OXFORDSHIRE COUNTY COUNCIL'S RESPONSE TO CONSULTATION ON THE FOLLOWING DEVELOPMENT PROPOSAL

Application no: 13/00321/OUT

Proposal: 1,000 dwellings, local centre, employment space (5,000sq.m), primary school and other supporting infrastructure, access to A361 – land south of Salt Way.

Location: South of Salt Way adjacent to Bloxham Road Banbury

# ILLUSTRATIVE DEVELOPMENT FRAMEWORK

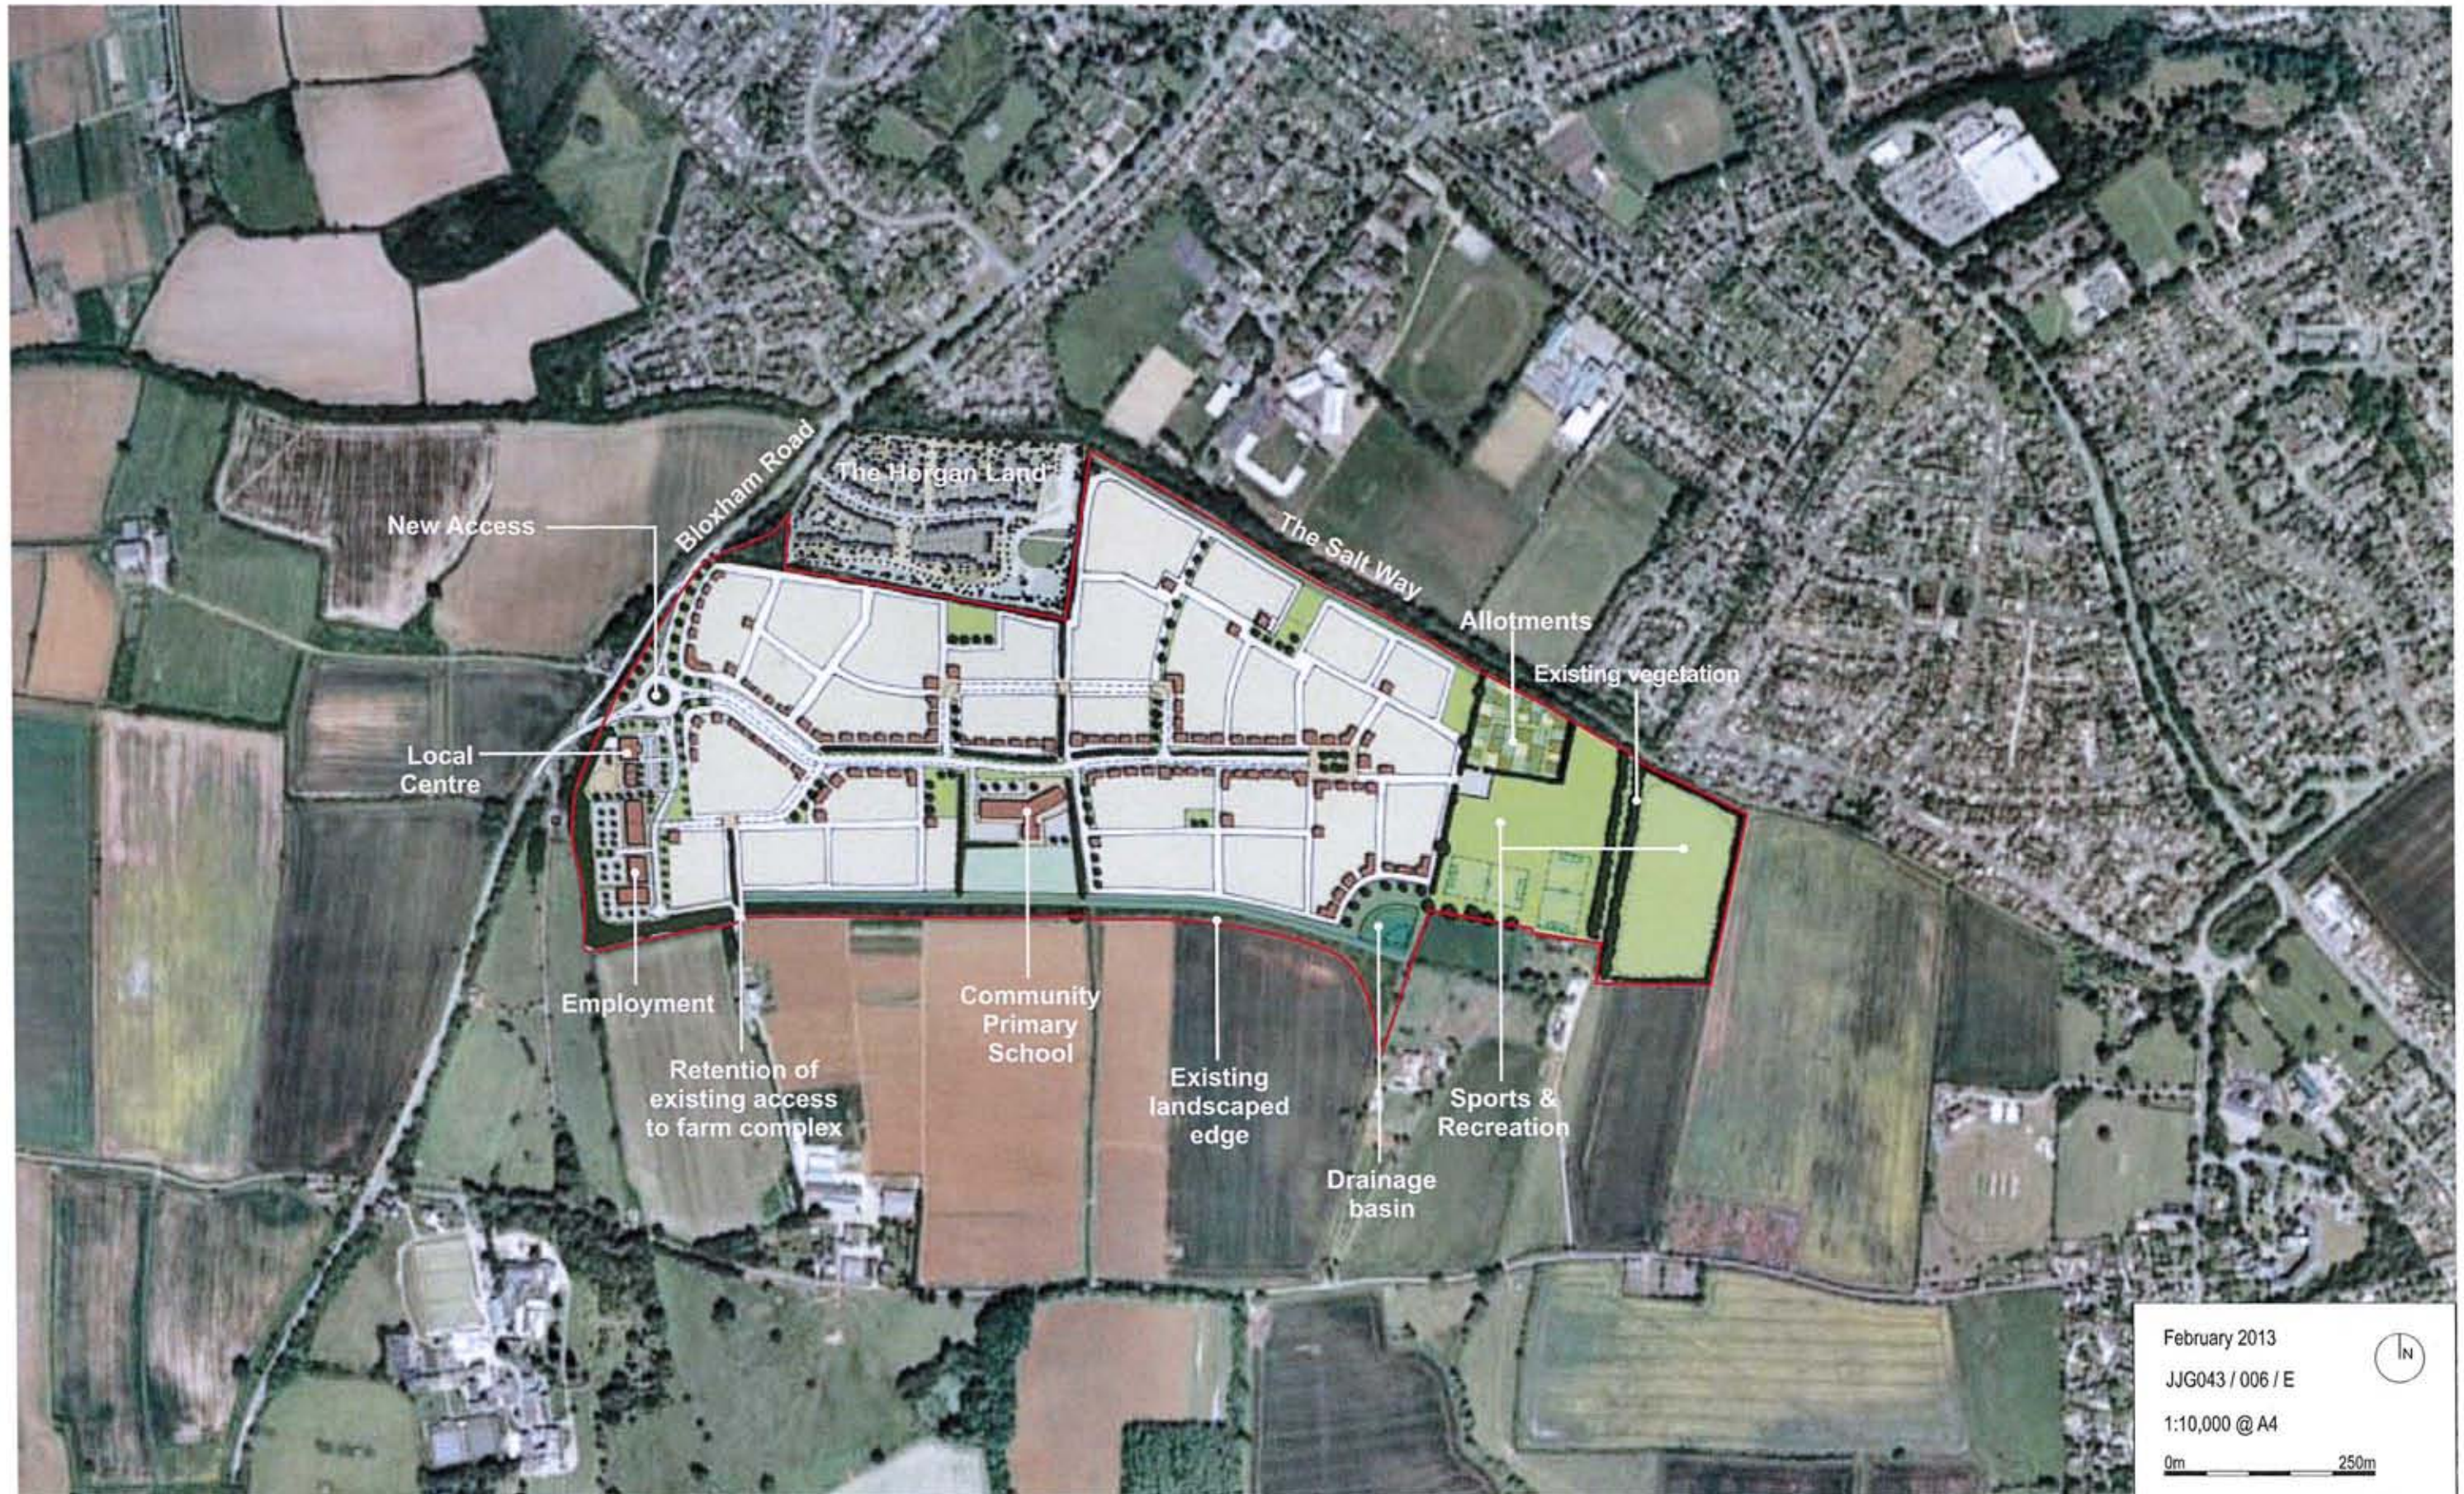
It is recognized that the site layout is illustrative. The comments below should be taken into account should a reserved matters application be prepared in future:

- The development is currently designed to be inward facing, with its back against Bloxham Road which means:
 - It is difficult to integrate the development site with the rest of the town
 - It makes it difficult to strengthen Bloxham Road as a core radial route into Banbury town centre.
 - It will be hard to create attractive bus, walking and cycling routes along the direct radial desire line into the town centre
- There is poor connectivity and infiltration with the neighboring development site, the Easington residential estate and Bodicote, particularly for vehicles.

- The site is effectively a large cul-de-sac, served off of a single access junction. This is poor both in connectivity and urban design terms. The site does, however, provide pedestrian and cycle access onto the Salt Way Cycleway.
- The internal road layout could be simplified and made more open to allow better pedestrian and cycle access and make the development easier to navigate.
- The proposed junction on Bloxham Road does little to take advantage of the site's position on a radial route, especially with the tree rows / screening.

The suggested routing of buses through the development does not meet the principle of encouraging commercially viable bus operation, which is best met by providing direct services. This new bus service should continue along the spine road to the 'shared surface urban square', thus maximising the penetration of the development (and hence accessibility to the bus stops). The developer would be required to provide an intermediate place for the bus to turn around, until the full route is available to the Shared Surface Urban Square.
